**ADC Planning Consultation
Response from the Historic Buildings Adviser**

Application Number	FG/120/12
Address	The Old Barn, Ferring
Description	Amendments to approval FG/6/12/ for COU. Addition of car shelter.
Case Officer	Anita Gardner
Site Visit

NOTES :		
DATE	REV.	COMMENTS
10-10-12	A	Planning issue

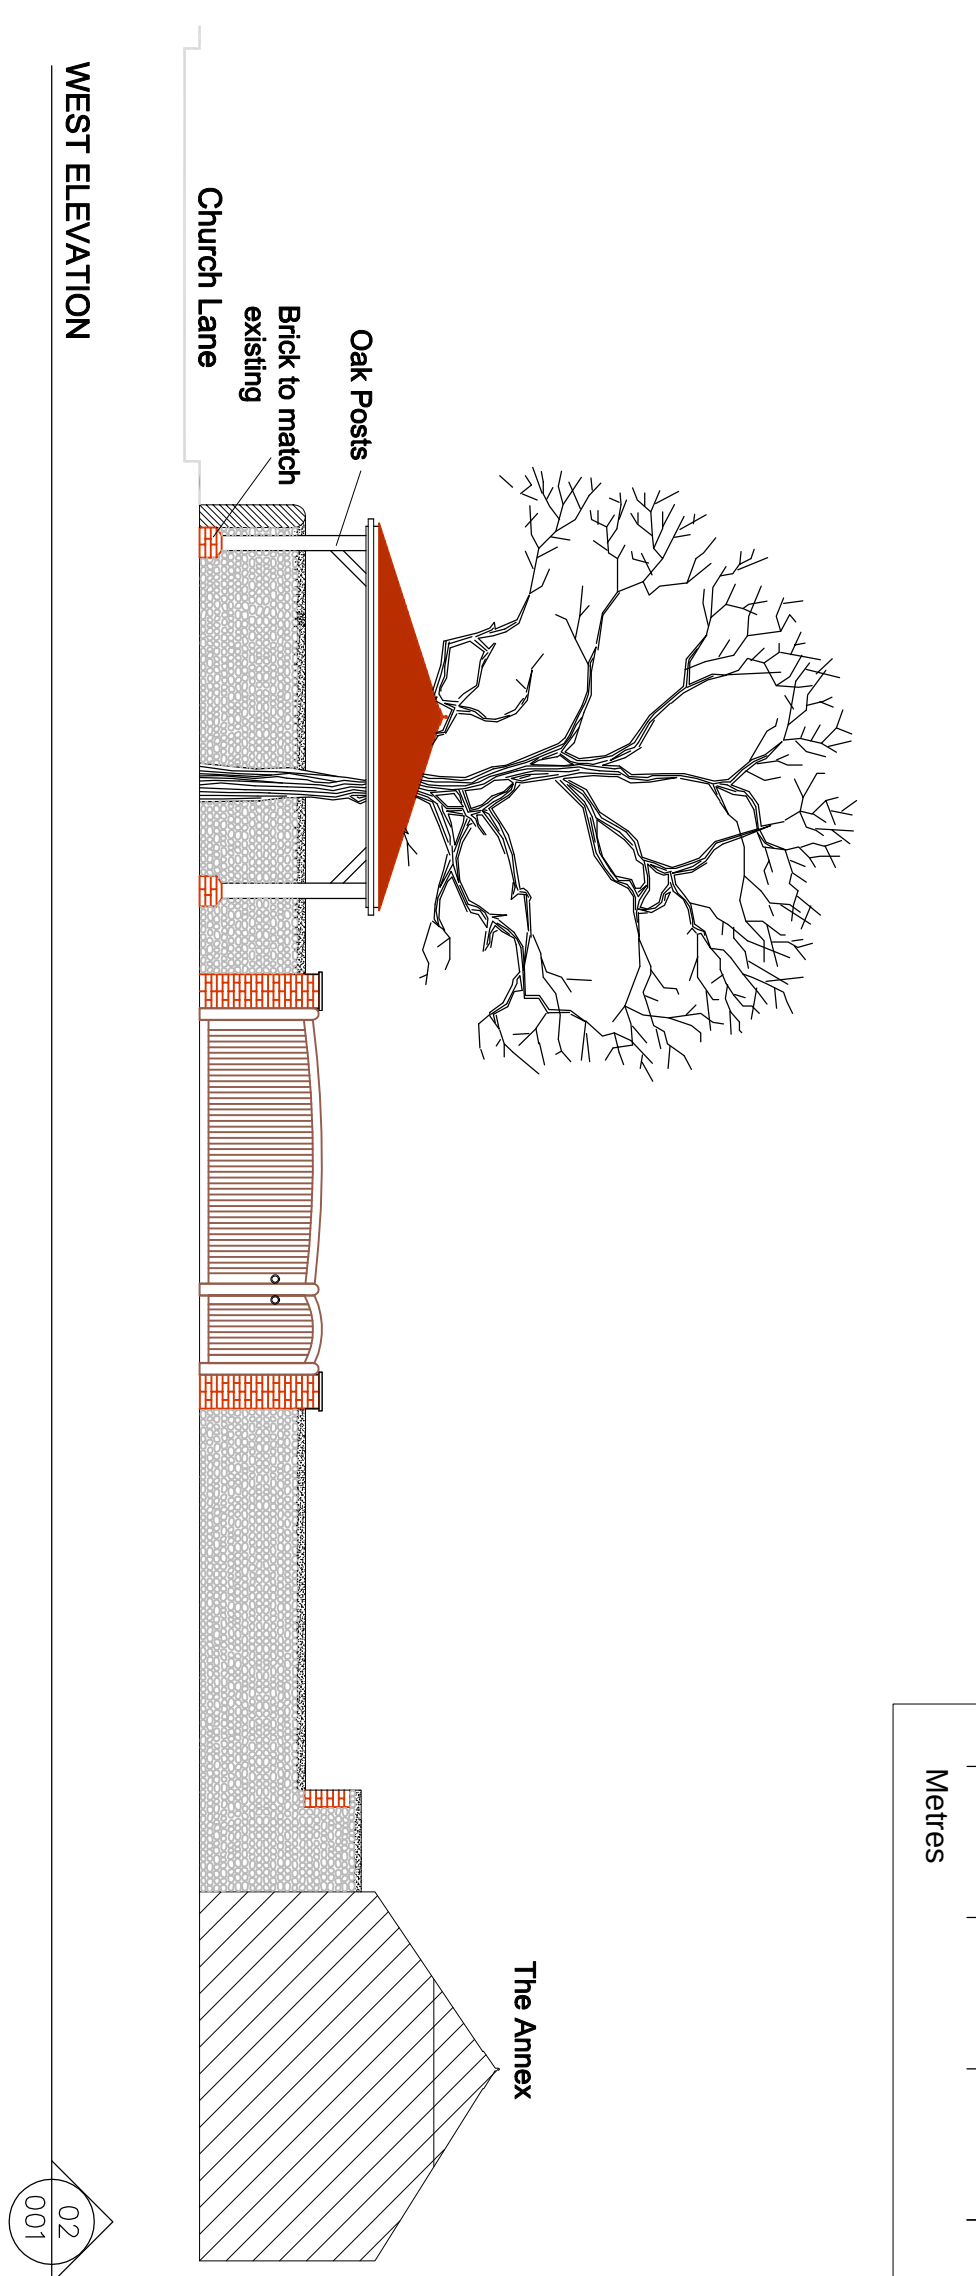
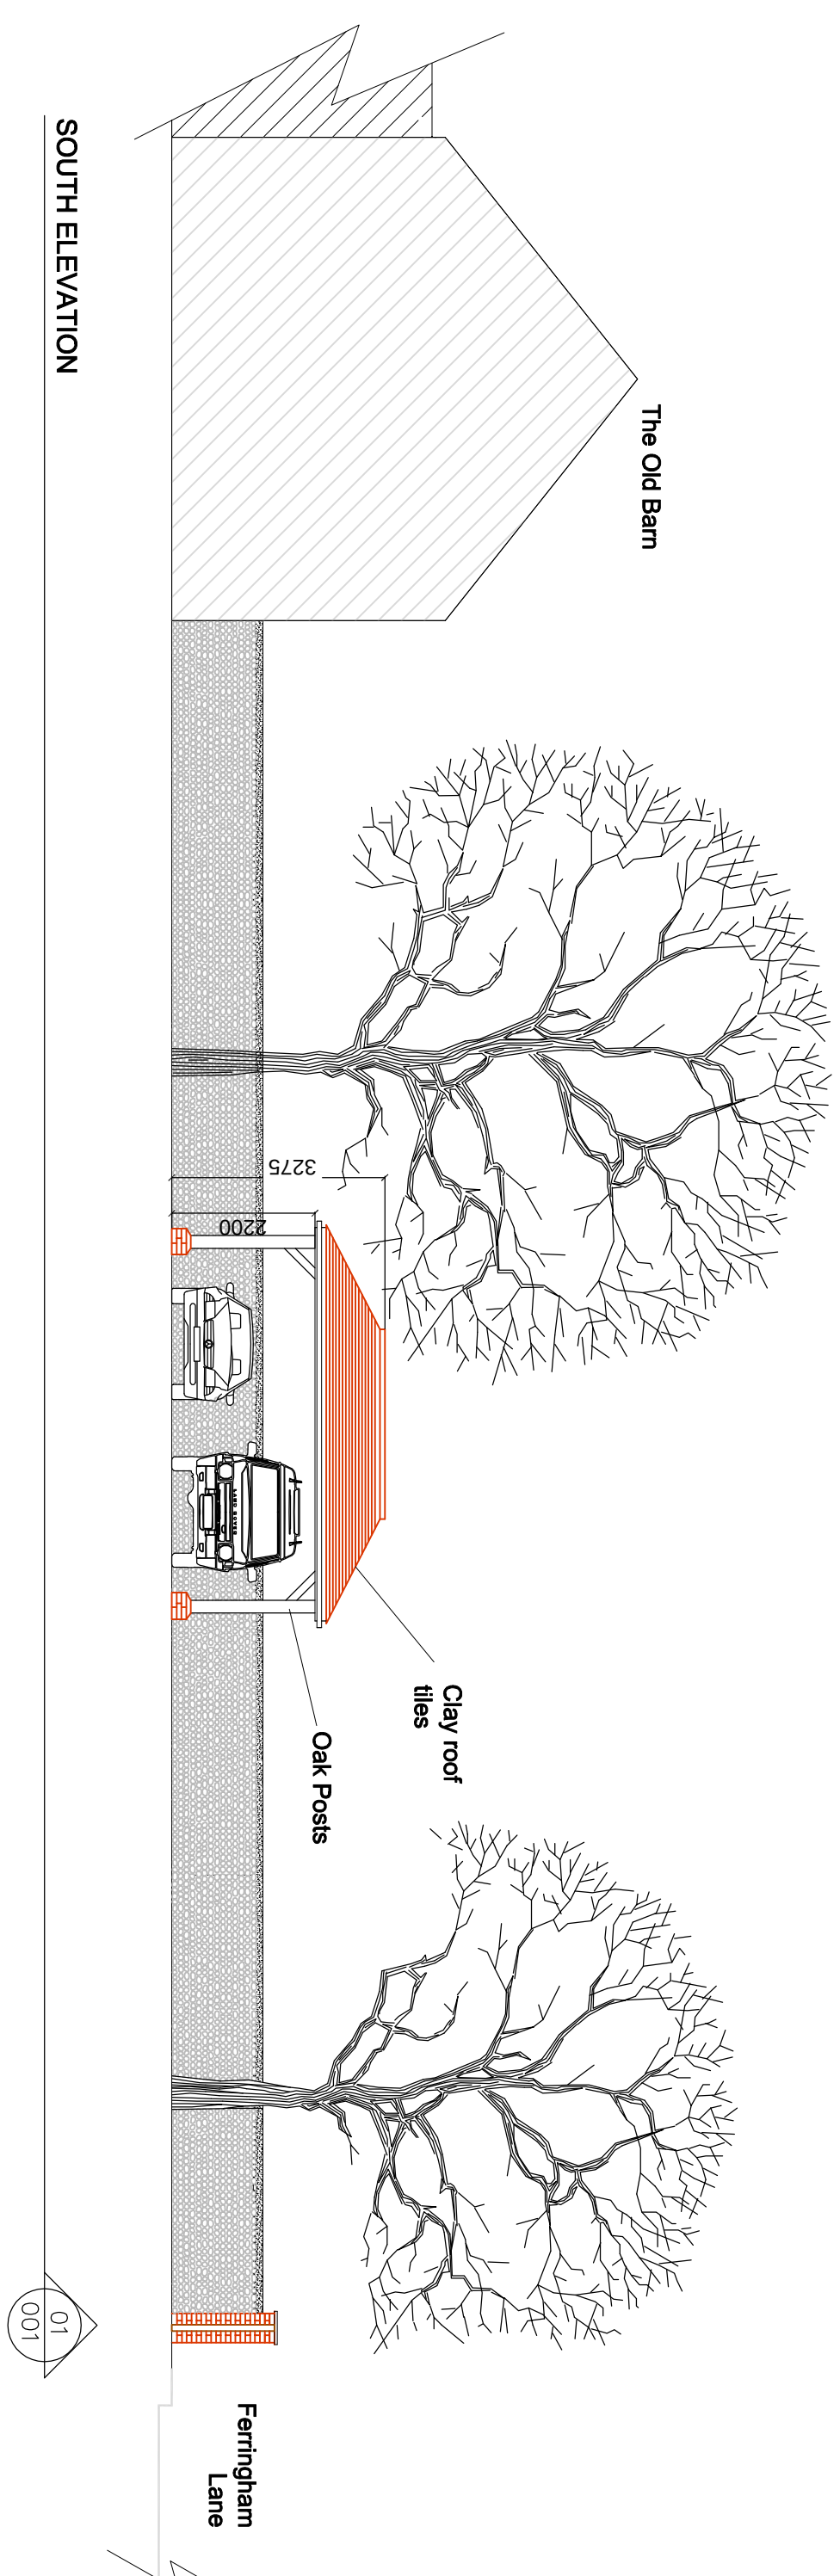
The 'cart shed' design proposed here, by comparison, is fully open and not particularly convincing in this context. It is also quite different in design from the historic examples provided which have steeper roof slopes more appropriate for clay tiles. As such, it is not appropriately 'agricultural' in character and in turn could detrimentally affect the setting of the historic building group, their appreciation and amenity.

That said, I would suggest that any type of shelter is resisted here on the basis that it would affect the setting of the historic building group.
